M3 Junction 9 Improvement Scheme

7.12.7 Statement of Common Ground with Cycle Winchester (Rev 1)

**7.12.7 STATEMENT OF COMMON GROUND WITH CYCLE
WINCHESTER**

This Statement of Common Ground has been prepared and agreed by (1) National Highways Company Limited and (2) Cycle Winchester

DRAWING TITLE  
FIGURE 2.5 - THE SCHEME: TEMPORARY TRAFFIC DIVERSION ROUTES  
APFP REGULATIONS 5(2)(a)  
SHEET 5 OF 12  
DOCUMENT REFERENCE 6.2

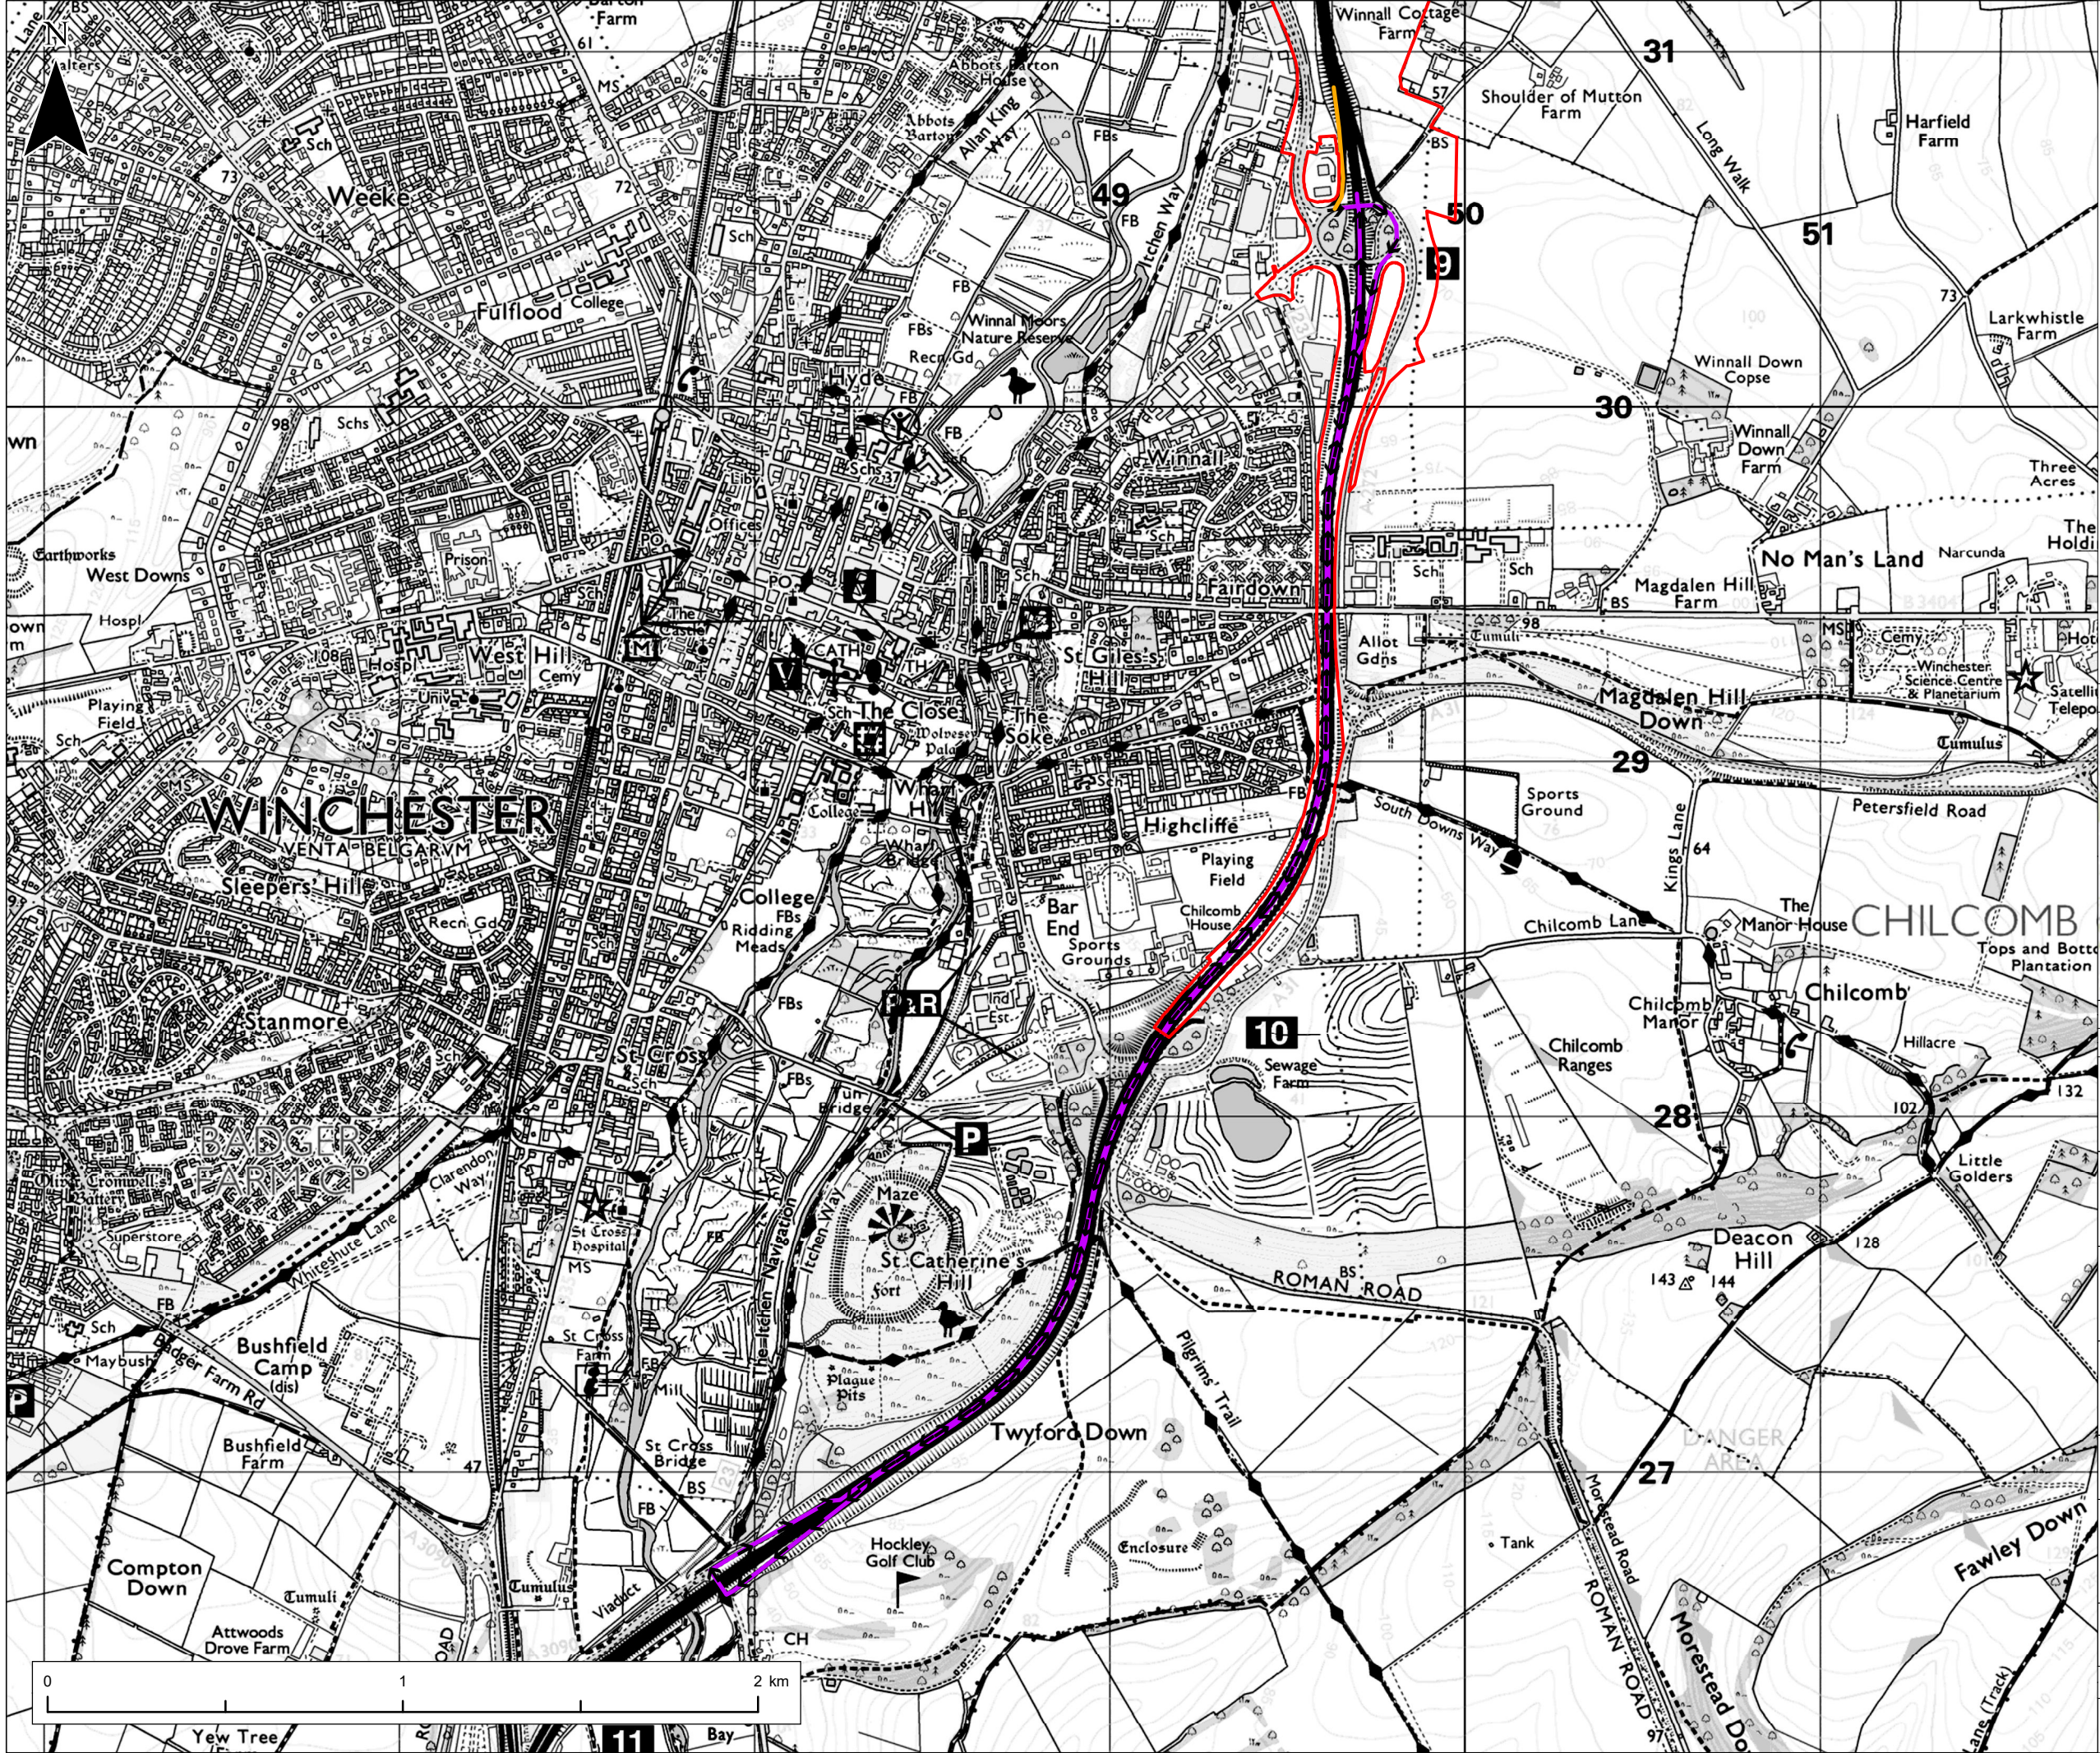
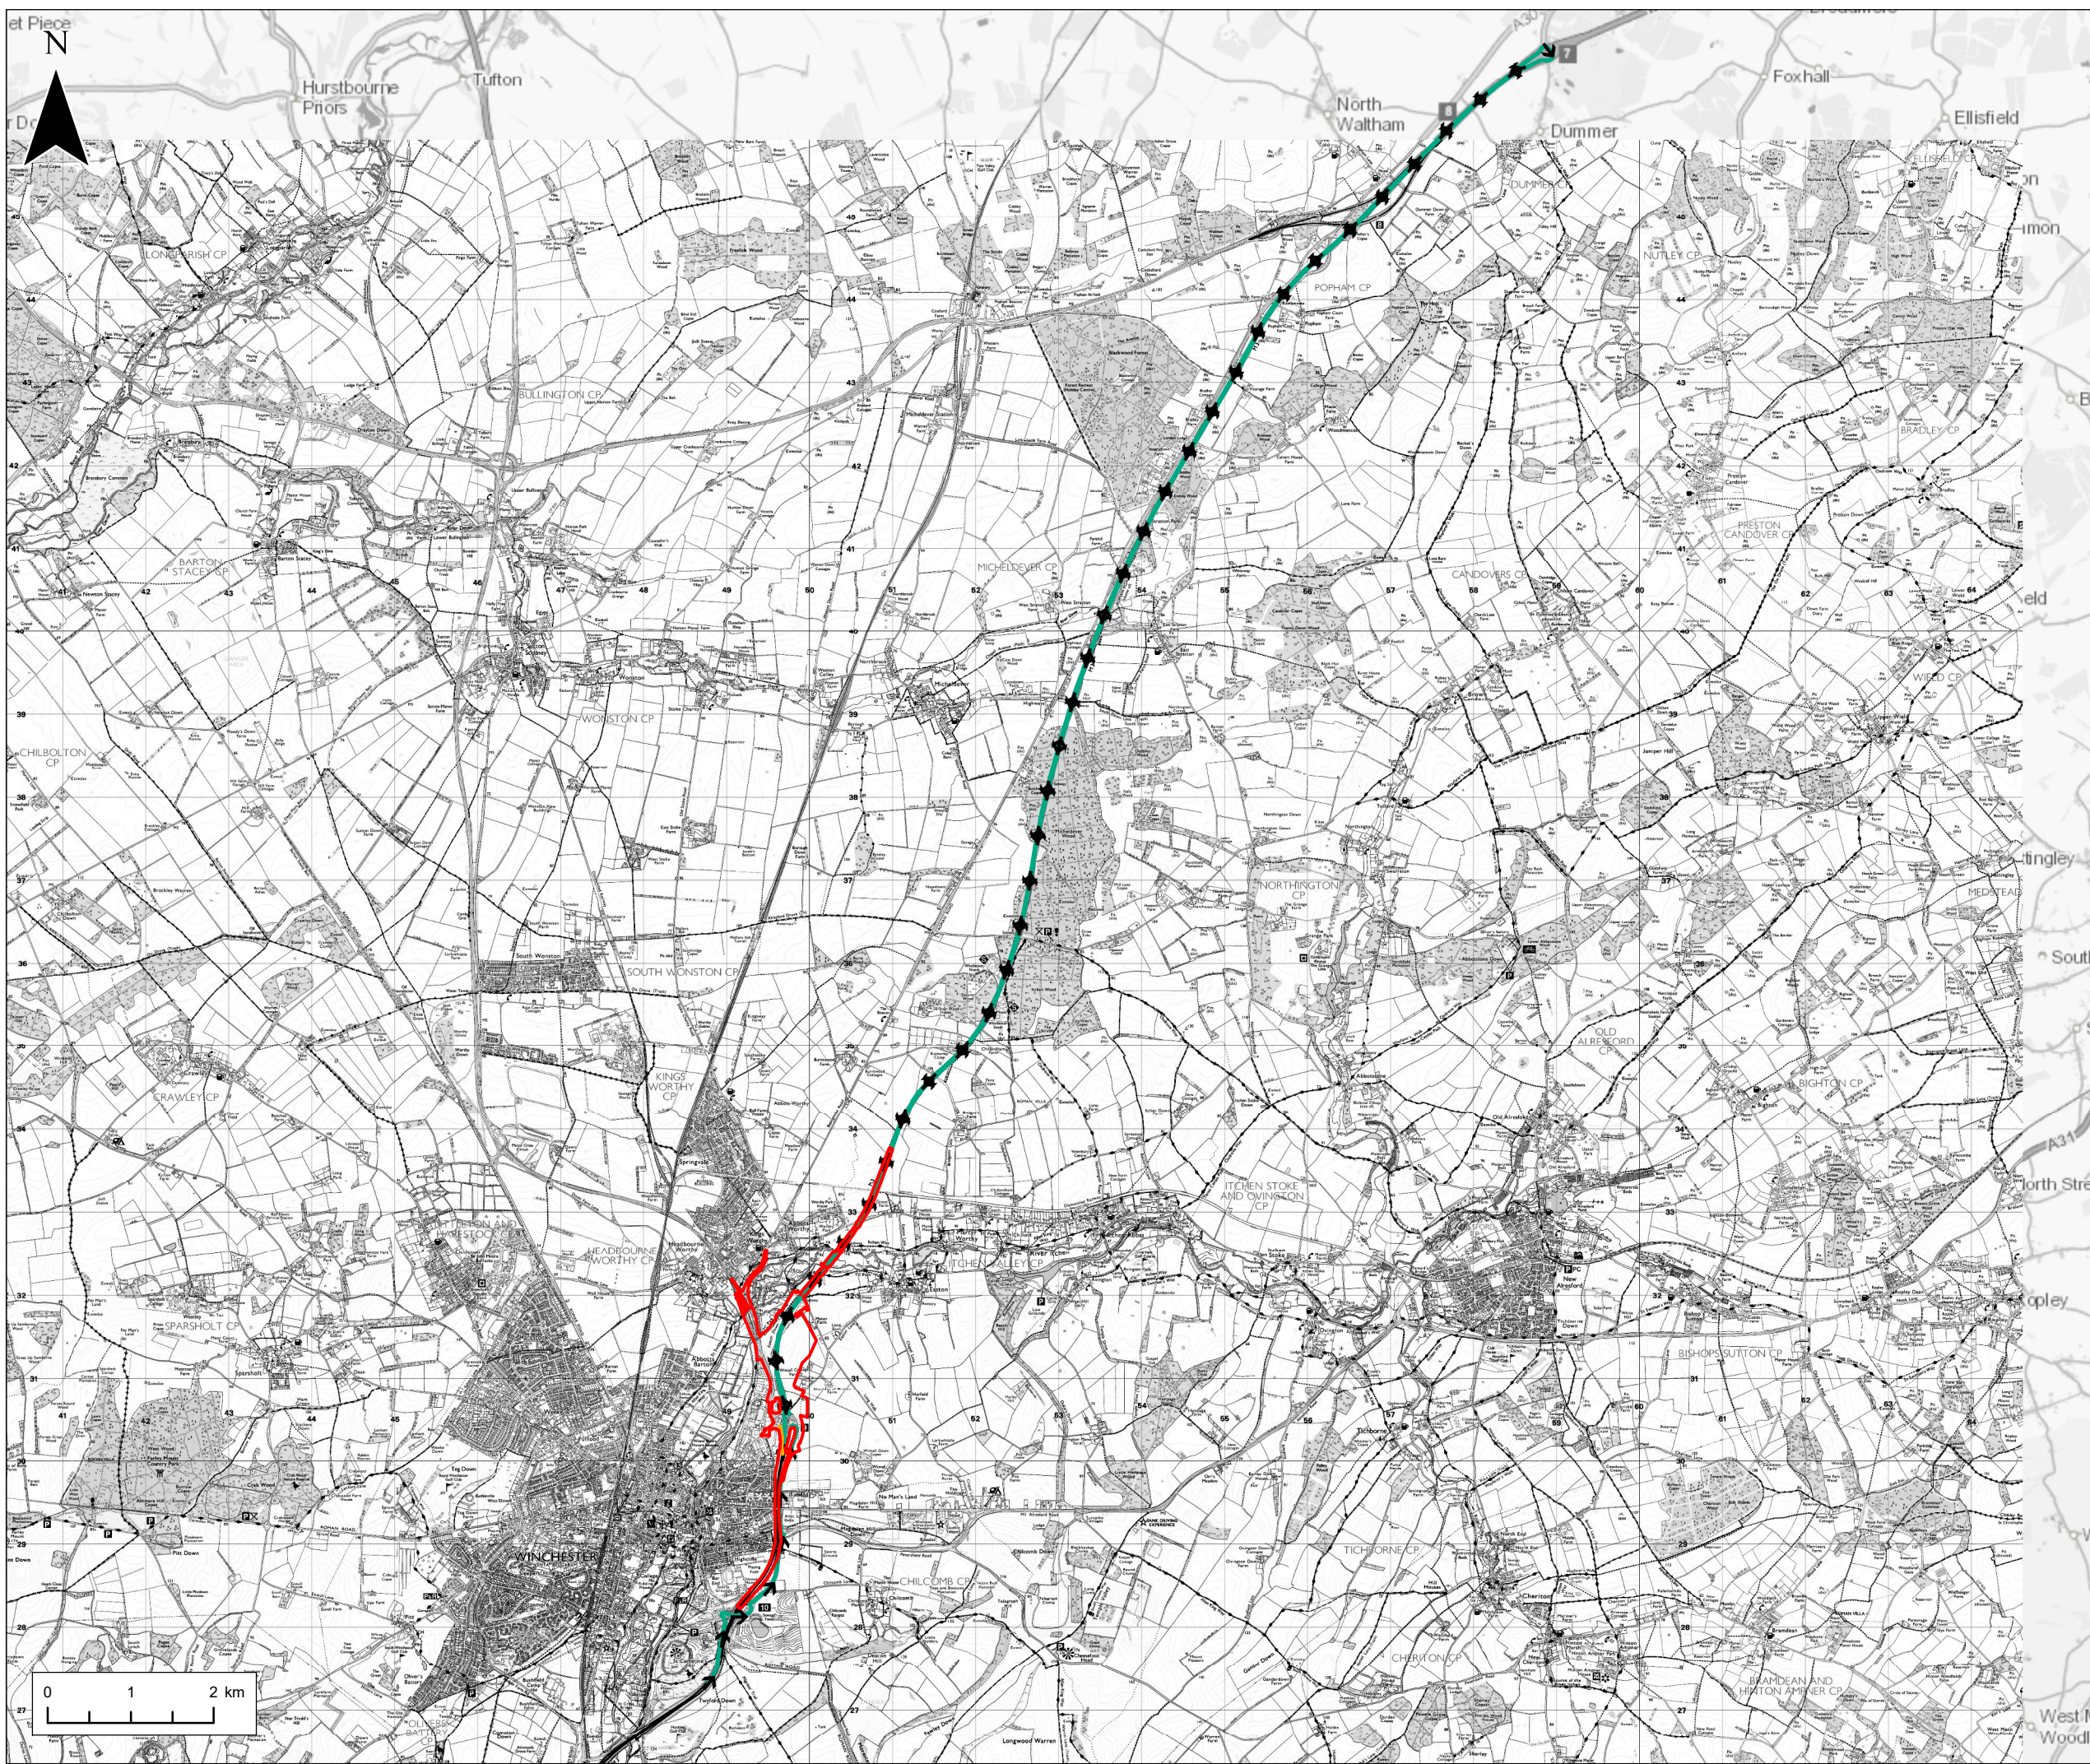
5.2	<p>Diversion routes Impact of traffic diversion on cyclists</p>	<p>Outline Traffic Management Plan (7.8, Rev 1), Figure 2.5 of Chapter 2 (The Scheme and its</p>	<p>Cycle Winchester has the impression that the project team has not yet considered the impact that traffic diversions during construction will have on cyclists. Examples of areas where the diverted traffic might have an impact on cycling</p>	<p>Diversion routes via the B3047, the B3420 Andover Road and road east of the junction (A31) will be implemented at various stages of the Scheme. The works are planned to be undertaken during overnight off-peak closures</p>	<p>Not agreed</p>	<p>8 November 2023</p>

Reference	Issue	Document References (if relevant)	Cycle Winchester's Position	National Highways' Position	Status	Date
		<p>Surroundings – Figures (Part 3 of 4) of the ES (6.2, APP-063)</p>	<p>include many of the major routes in and out of Winchester, as a Junction 9 closure or complete M3 closure would force more traffic onto these roads. Some examples:</p> <ul style="list-style-type: none"> ▪ B3047 Worthy Road/Martyr Worthy Road ▪ B3335 St Cross Rd and Twyford Road ▪ B3420 Andover Road ▪ B3330 Bar End Road ▪ Minor roads, especially in the upper Itchen valley east of the junction <p>In addition, the location of the site offices and parking immediately to the east of the junction suggests that the likely travel-to-work route of staff working on the project would clash with the proposed cycling diversion routes as well as impacting walkers, cyclists and horse riders on the section of NCN23 near Easton village. (See 6.2 Environmental Statement Chapter 2 The Scheme and its Surroundings - Figures Part 1 of 4).</p> <p>Again, we would like to see a clear consultation process that will ensure that consultation happens, that the effects on non-motorised road users are accounted for, and appropriate measures are taken.</p>	<p>(when there is less traffic on the network) and several extended weekend closures.</p> <p>The B3335 St Cross and Twyford Road and B3330 Bar End Road have been referenced as secondary diversion routes and should only be used by non-motorway traffic, or for those accessing the residential area at Bar-End.</p> <p>There are mitigation measures for rat-running and this will be monitored throughout construction of the Scheme.</p> <p>National Highways commit to producing a PRoW Management Plan during detailed design. National Highways will have regard to Cycle Winchester's views during the development of the PRoW Management Plan during detailed design. This will include controls to manage the crossing of the haulage route and NCN Route 23 and on Long Walk.</p>
